PORTLAND MAINE

July 9, 2009

RE: 091-P-006 & 9 – Reed Avenue, Peaks Island – IR-1 Zone – Determination Letter

BOUNDARY AND TOPOGRAPHIC SURVEY
 ON

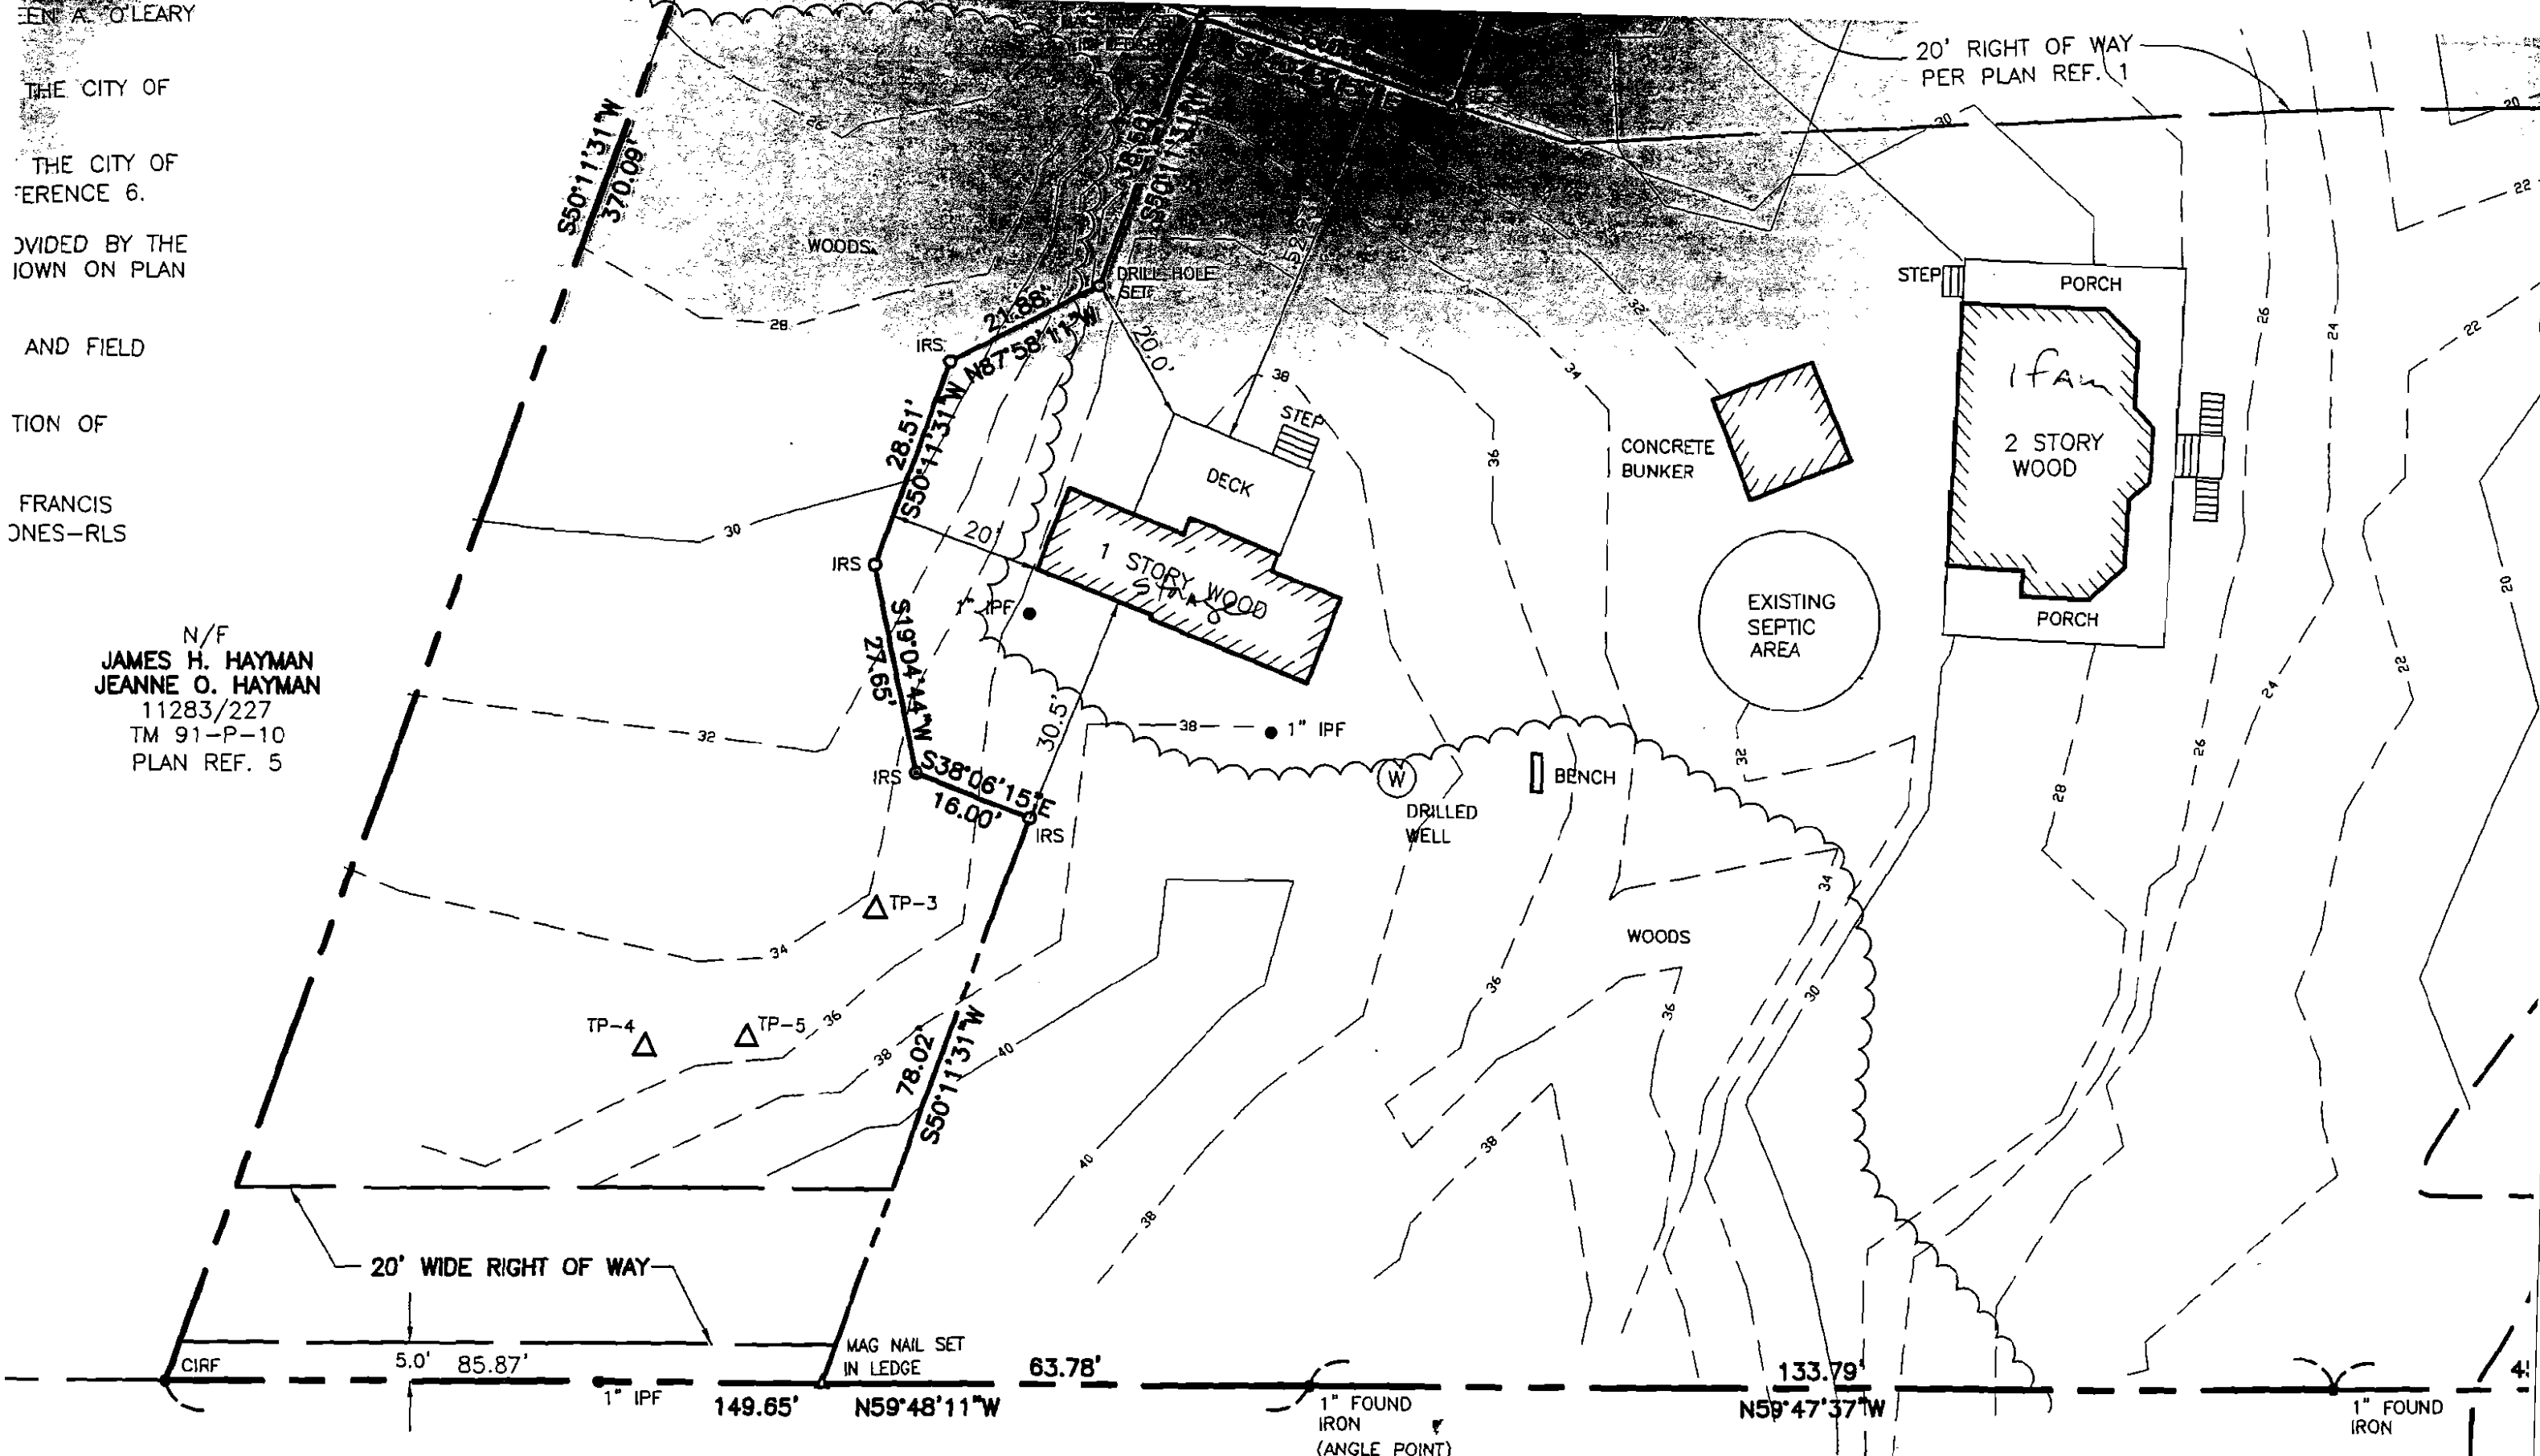
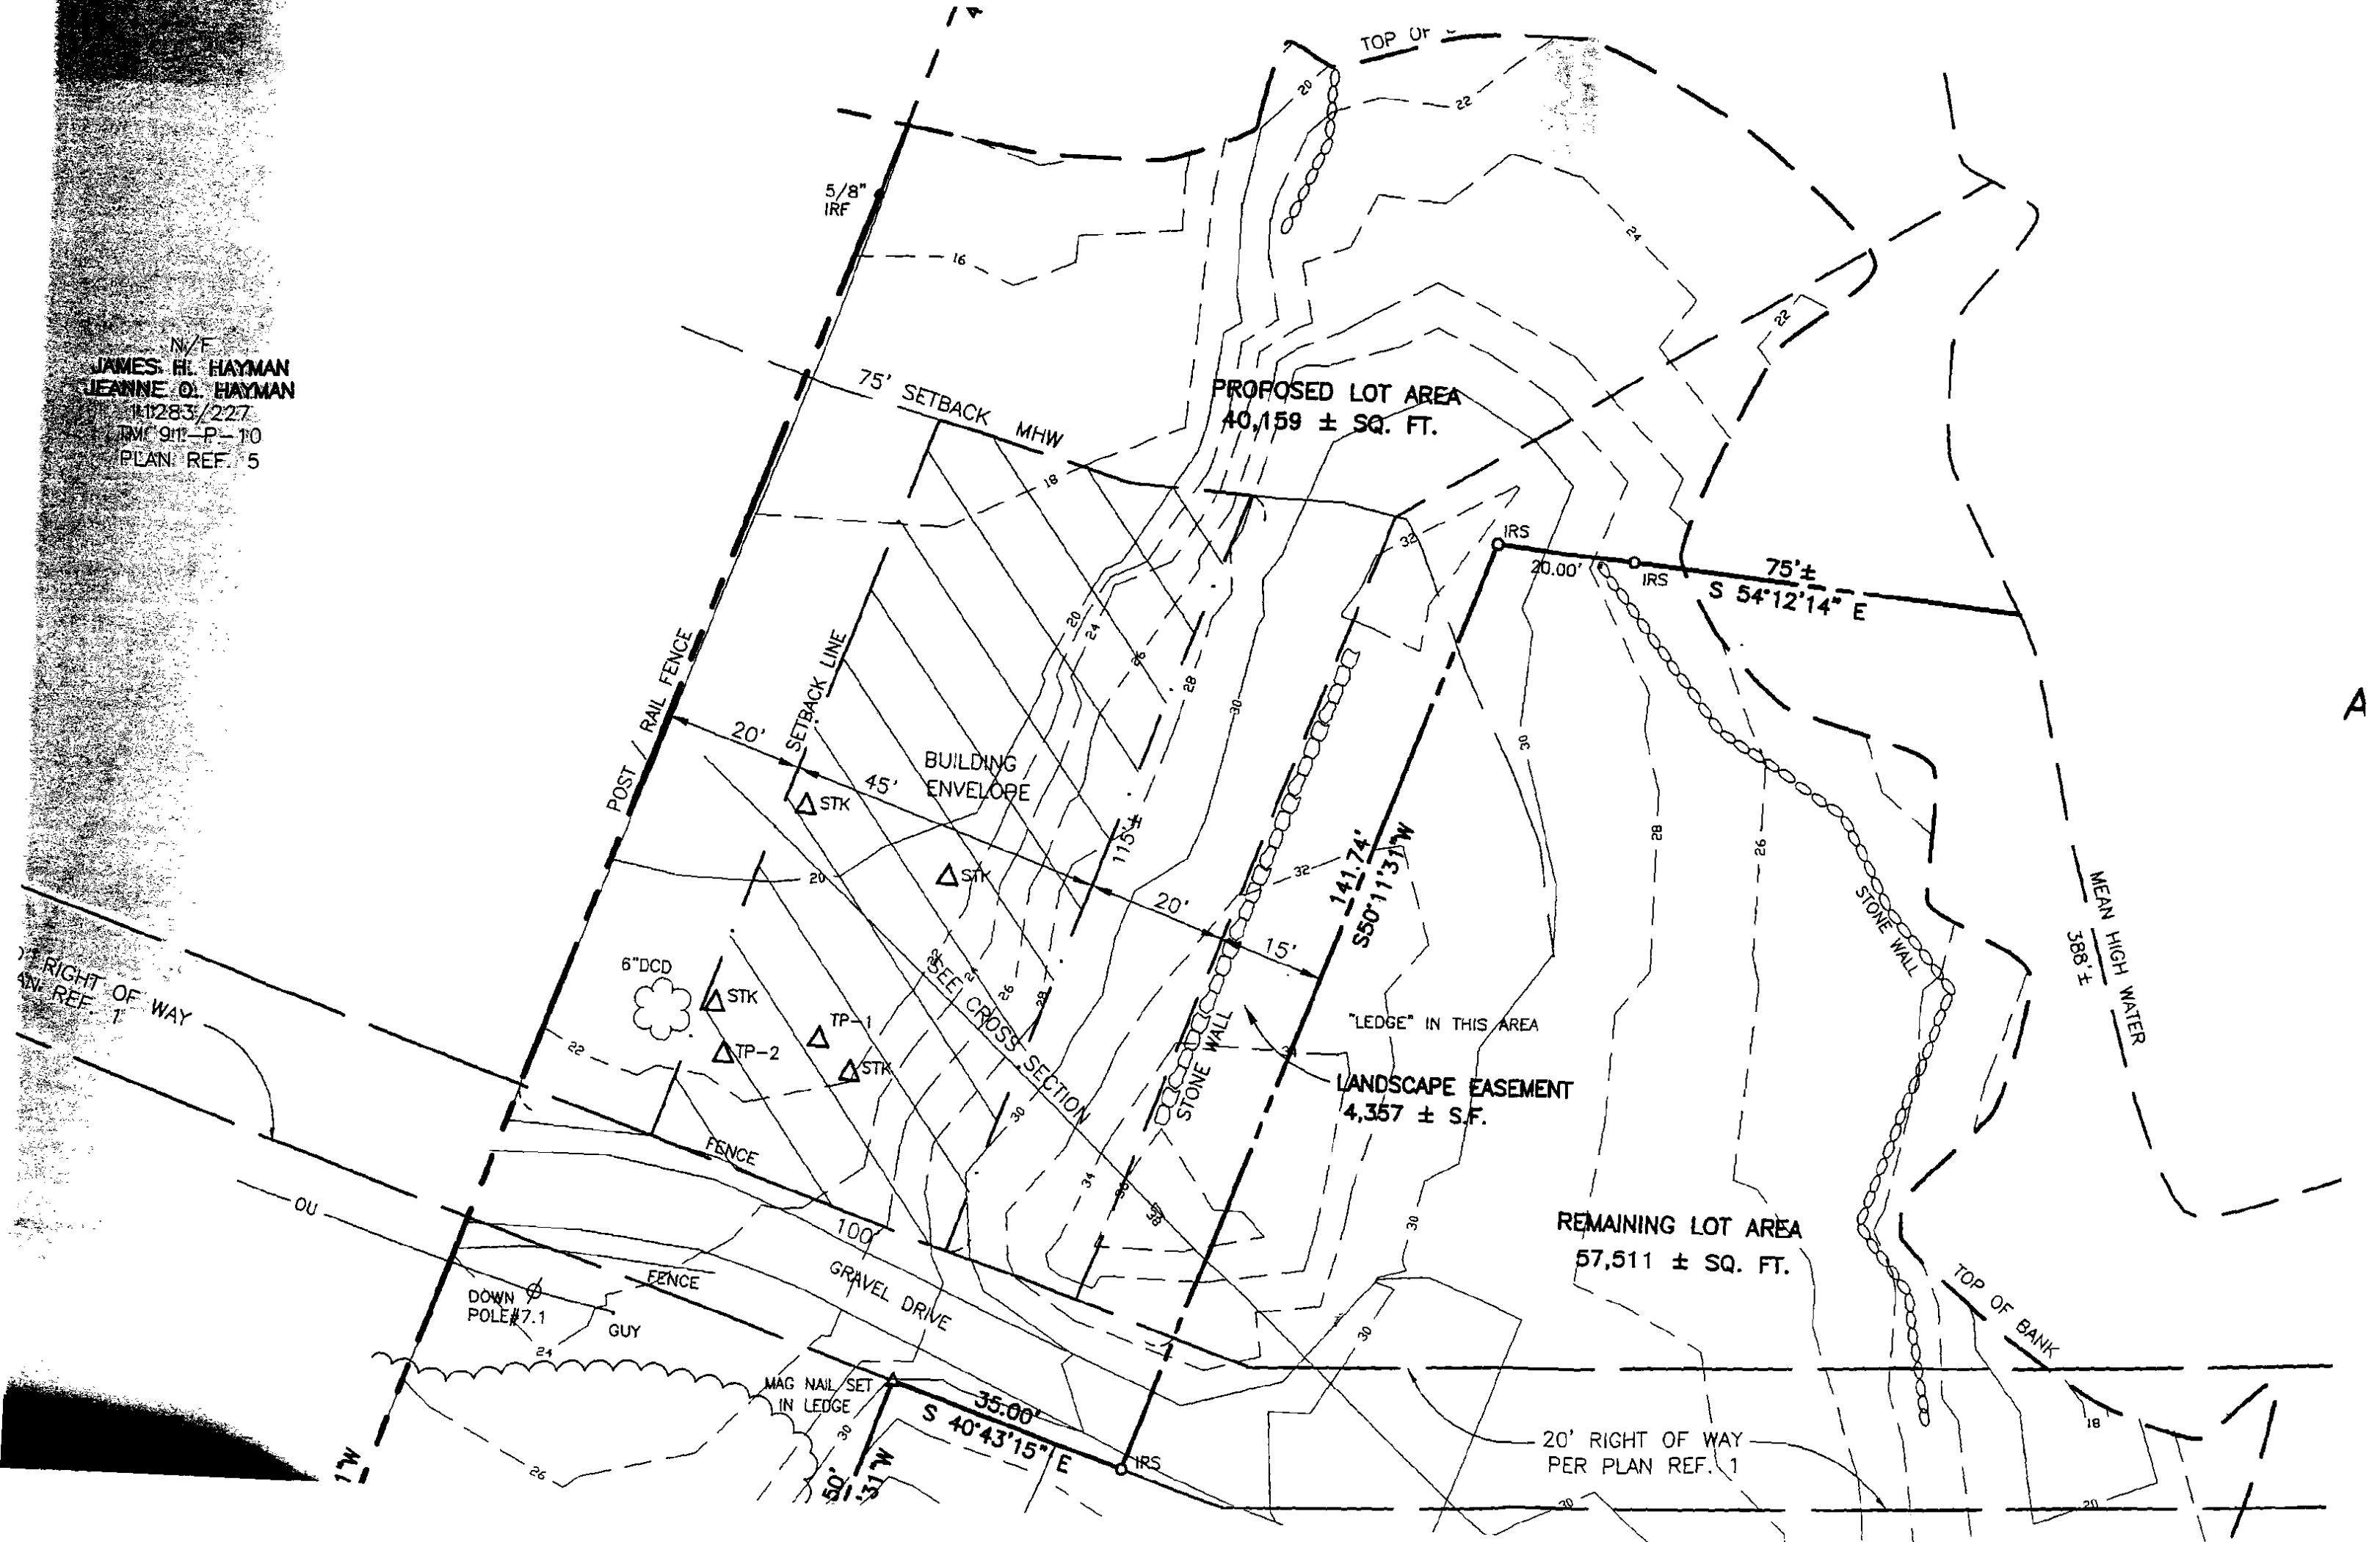
I am in receipt of your request to determine whether the new lot configuration would be allowable under the existing Land Use Zoning Ordinance. I have used the submitted survey plan dated December 17, 2008 with revision #4 of 06-09-09 prepared by Owen Haskell, Inc. It is noted that the submitted plan is unstamped and not signed.

The first concern relates to the street access and frontage as required by ordinance. There is an exception on the Islands to allow for permanent easements or rights-of-way to meet the minimum street frontage. When the two existing lots were created, there was a bit of correspondence that occurred in 1992. This office has accepted the original decision from Bill Giroux who was the Zoning Administrator at that time. The 20' right of way may be considered as street frontage. It is noted that the proposed lot shown as 40,082 square feet is considered one lot as previously determined. The right-of-way in this instance does not create two separate lots on either side of the right-of-way. Both lots have the 100 foot of frontage that is required.

The IR-1 zone requires a minimum lot size of 40,000 square feet of land area per lot when public water is provided. Public water is provided during the summer. The Ordinance does not restrict summer water from year round water. Both lots affected by the redefined lot line have a minimum of 40,000 square feet of land area.

All setbacks and lot coverage requirements of the IR-1 Zone are being met. Shoreland Zoning setbacks have been delineated and allow for a reasonable area to build. It is also noted that there are no impacted coastal bluffs in this area of Peaks that would change the Shoreland Zone setbacks.
